PLAN REVIEW SHEET

Petition #: RZP 2020-013

Address: 4029 South Tryon St.

Request: UR-2(CD)

RZ-1

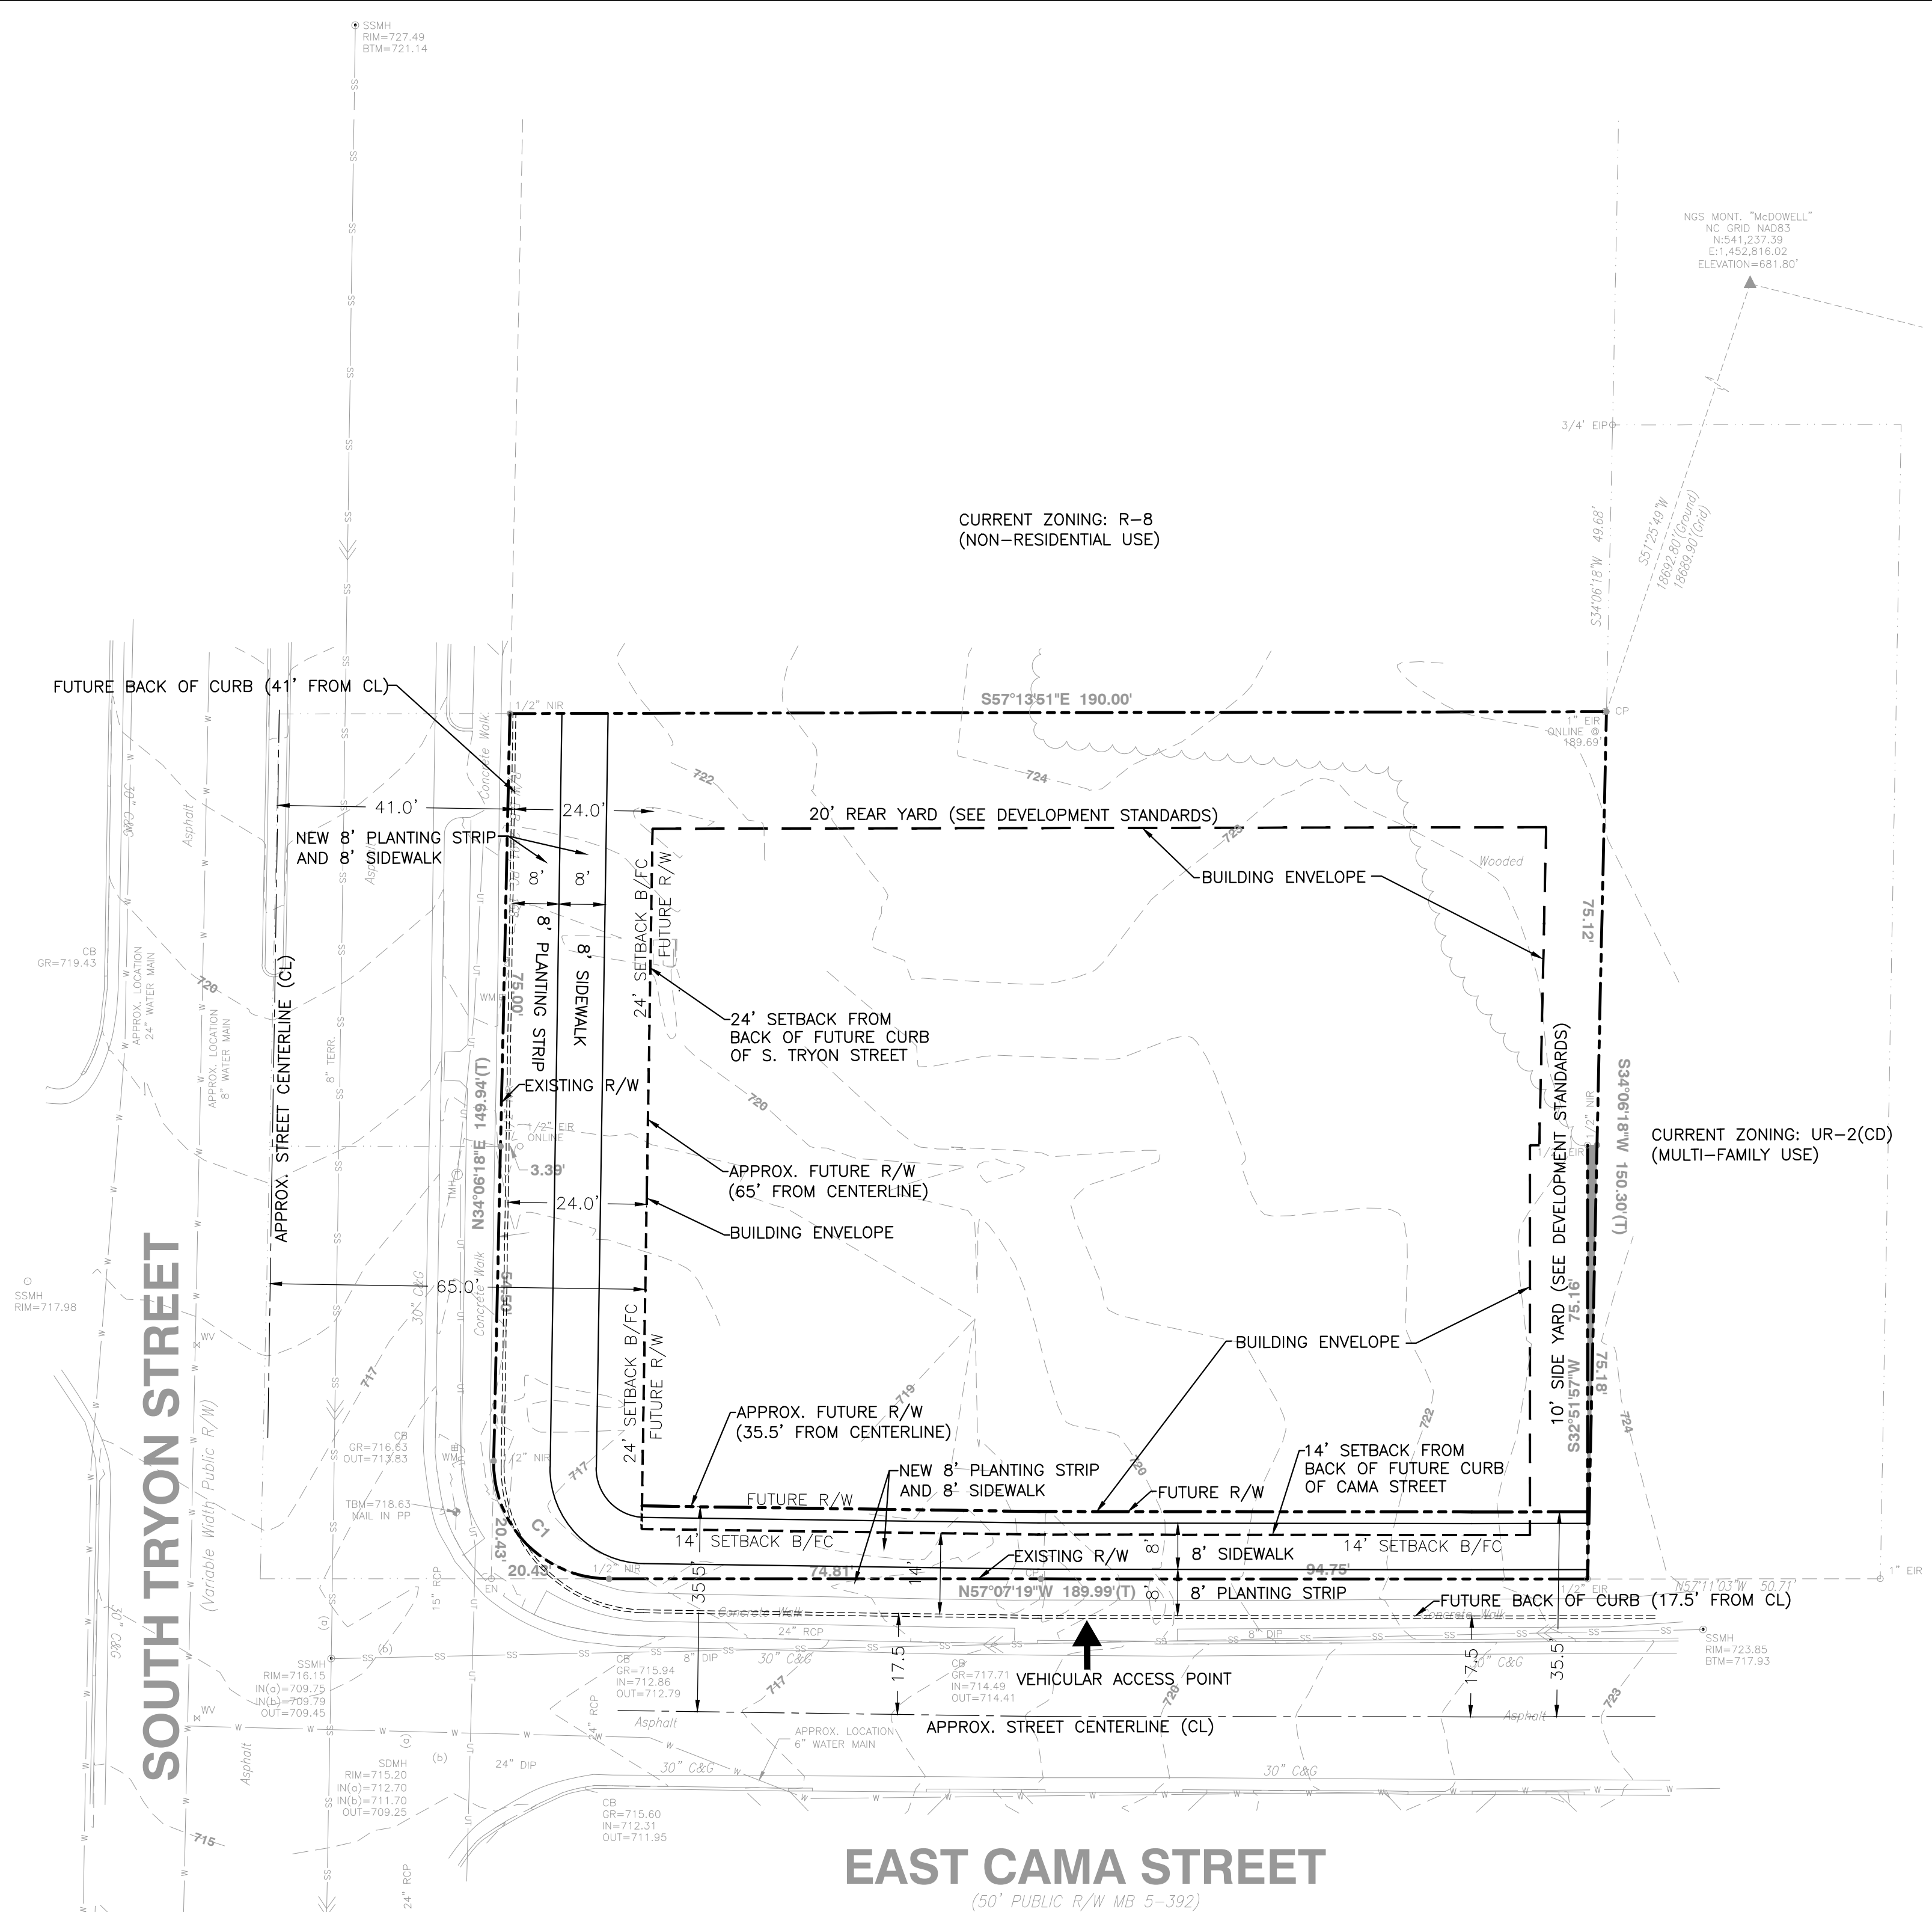
The site is located along CATS local bus route #12 and #16 on South Tryon Street. CATS requests the developer to construct an ADA compliant bus waiting pad per Land Development Standard #60.01B in the same general location as the existing stop. The final location of the pad will be coordinated with the developer through the permitting process.
